RE: Falcon Reserve Ponds (2nd Submittal)

Final Drainage Report:

EAST DRAINAGE SWALE

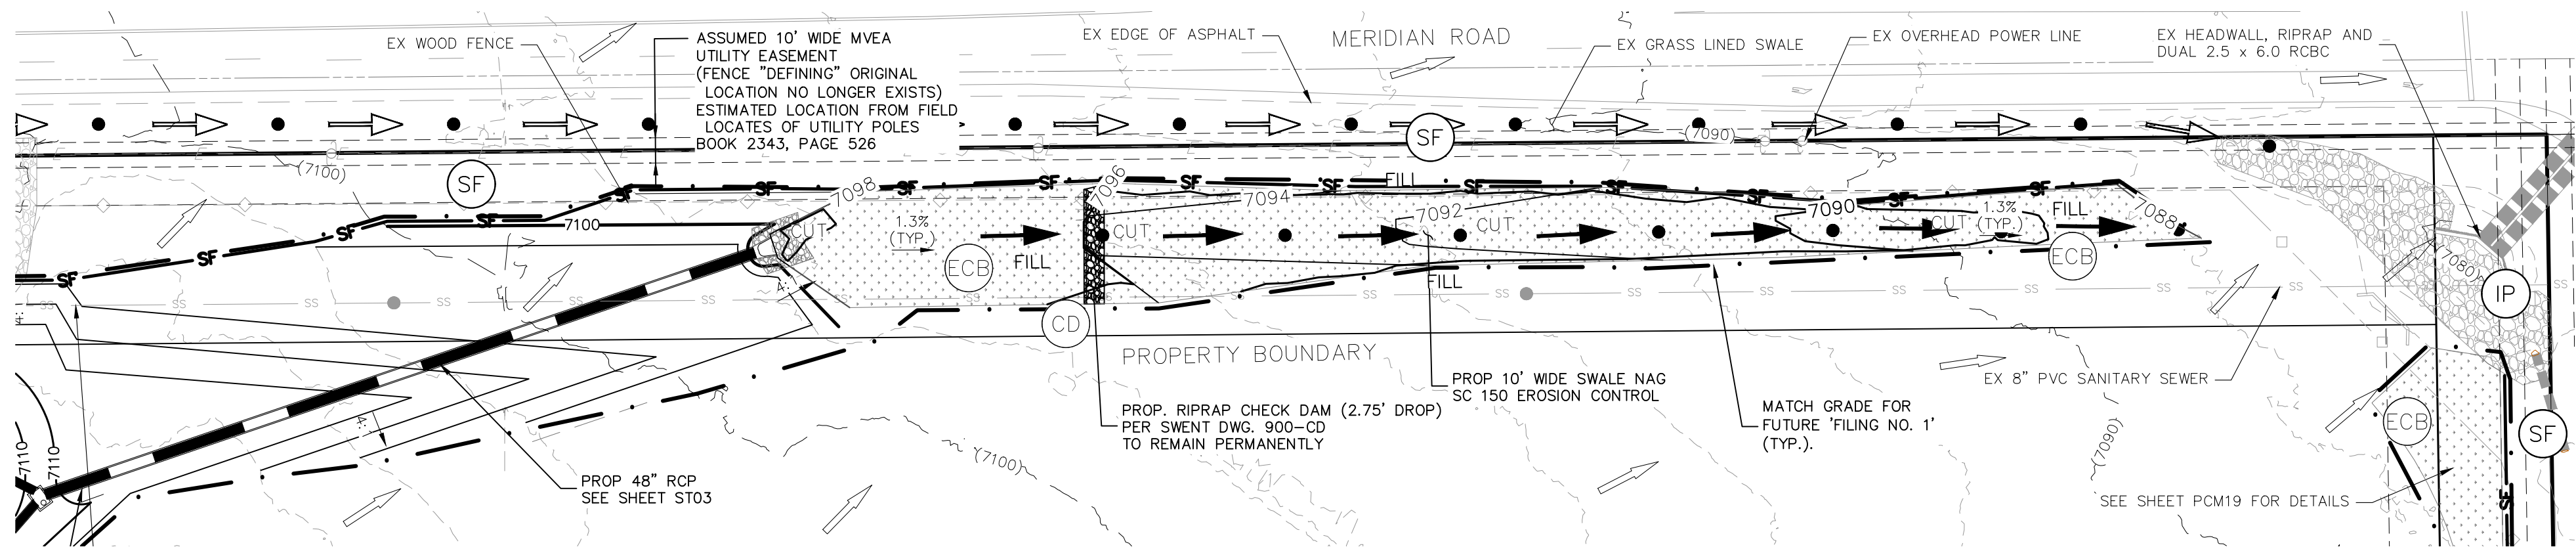
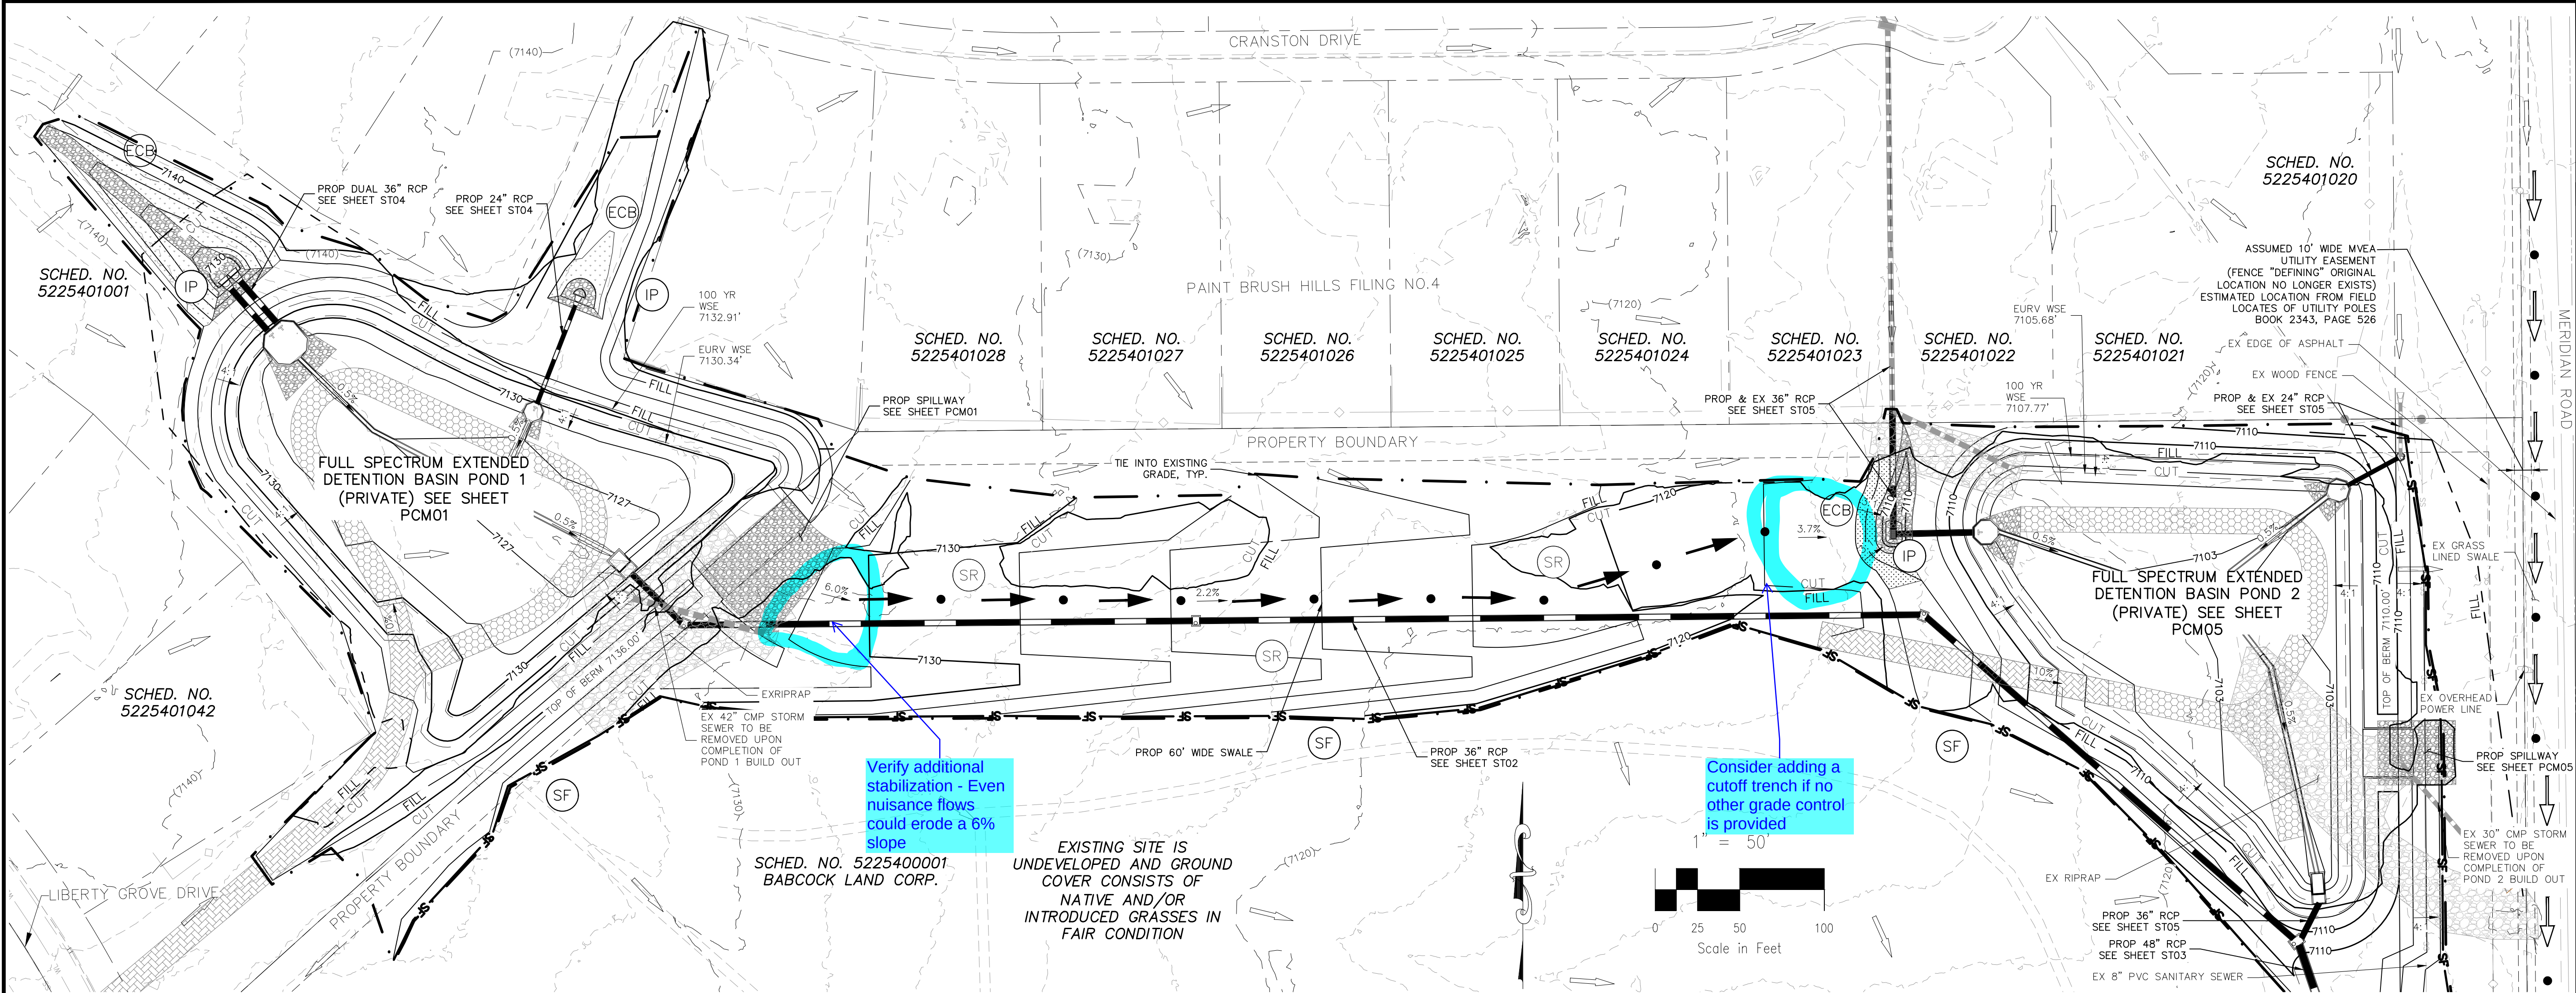
Comment 13: (eschoenheit) ‘Provide swale calculations that show new flows with lining and/or check dams that are not supercritical. DBPS called for check dams along meridian. This may have to be provided in the Final Plat Final Drainage Report’

Comment 15: (EPC Engineering – Jeff Rice) ‘Supercritical flows in any area require full stabilization’

Section E1-E1 and Section E2-E2 drainage swales were updated to reduce to ‘subcritical’ flow. These swales are to be lined with an erosion control blanket (North American Green SC 150 or equivalent). Also, riprap check dams were added provide stabilization. Please reference updated calculations in the FDR Appendix.

Section E1-E1 and Section E2-E2 drainage swales were updated to reduce to ‘subcritical’ flow. These swales are to be lined with an erosion control blanket (North American Green SC 150 or equivalent). Also, riprap check dams were added provide stabilization. Please reference updated calculations in the FDR Appendix.

FALCON RESERVE PONDS		POND 3 OUTLET STRUCTURE PLAN	
PROJECT NO. 43-144A		DATE: 08/10/2026	
DESIGNED BY: GT		SCALE: HORIZONTAL: N/A	
DRAWN BY: GT		VERTICAL: N/A	
CHECKED BY: VAS		SHEET 11 OF 21	
PCM 11

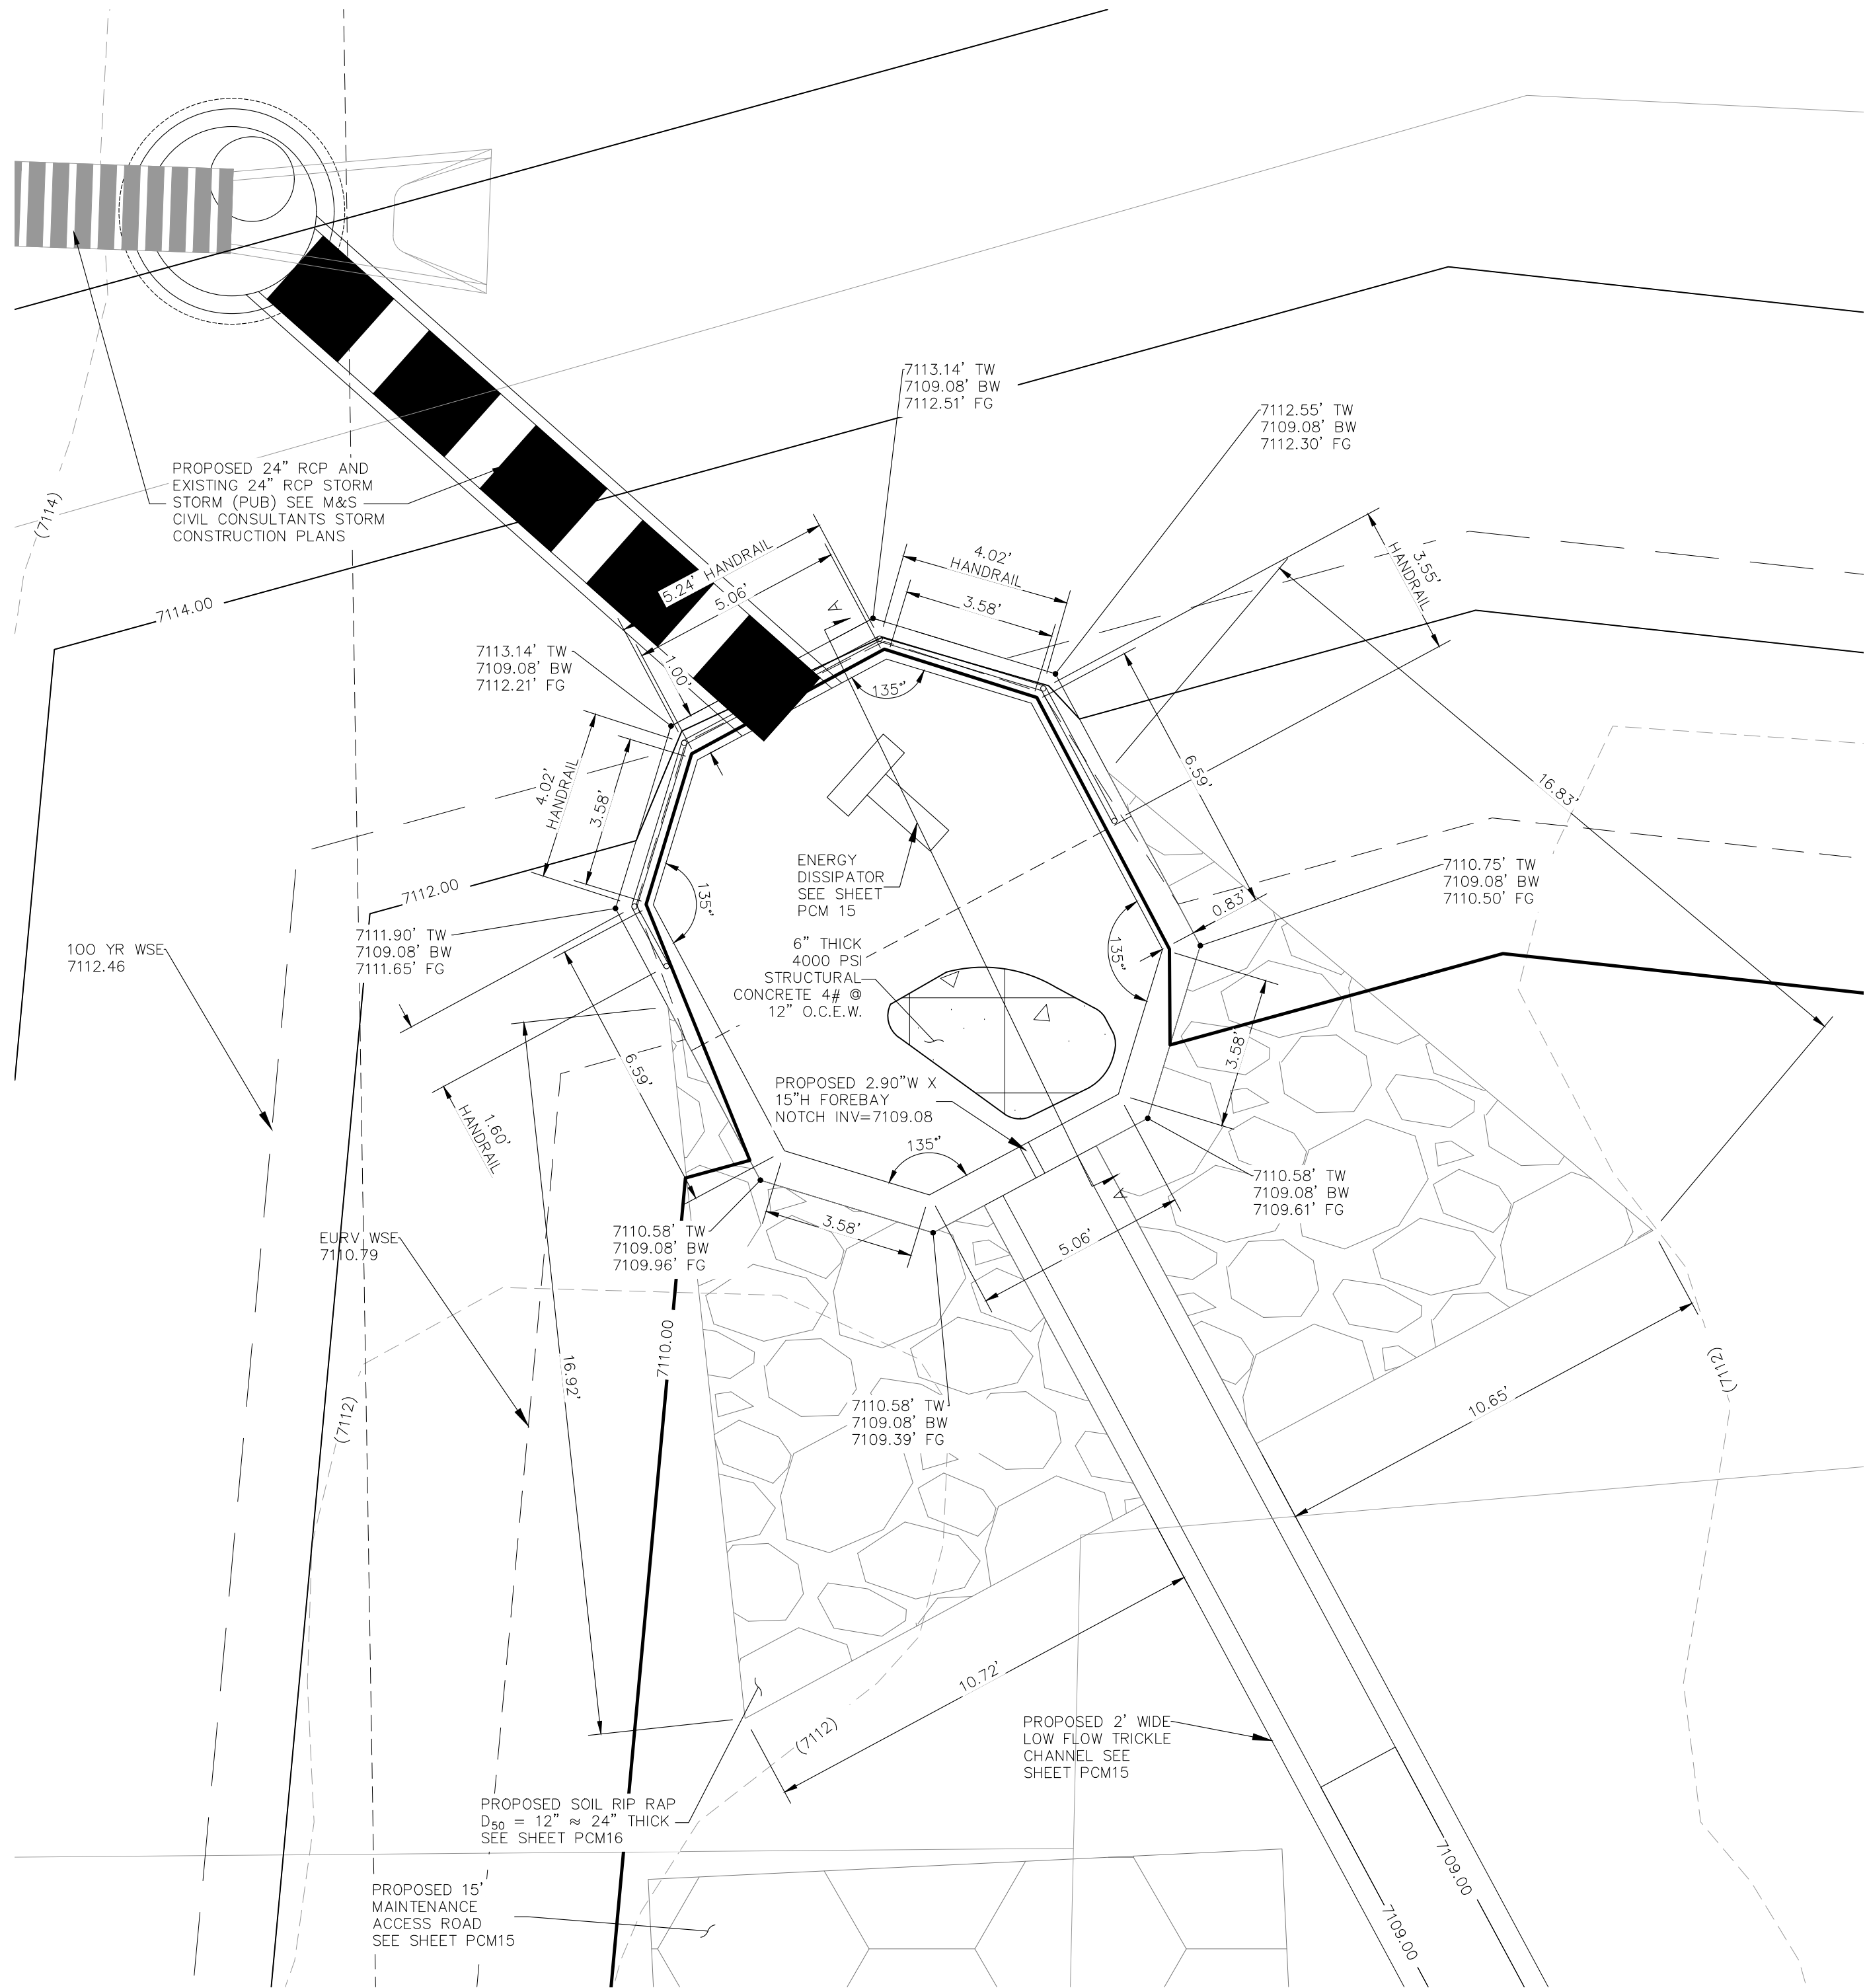
Comment 5: (EPC Stormwater – Zachary) ‘Calcs do not match details in plans’ (Pond 3)

M&S Response: This value is consistent with both the Storm & PCM Plans and the MHFD spreadsheet, confirmed this should be 2.5 sq inches.
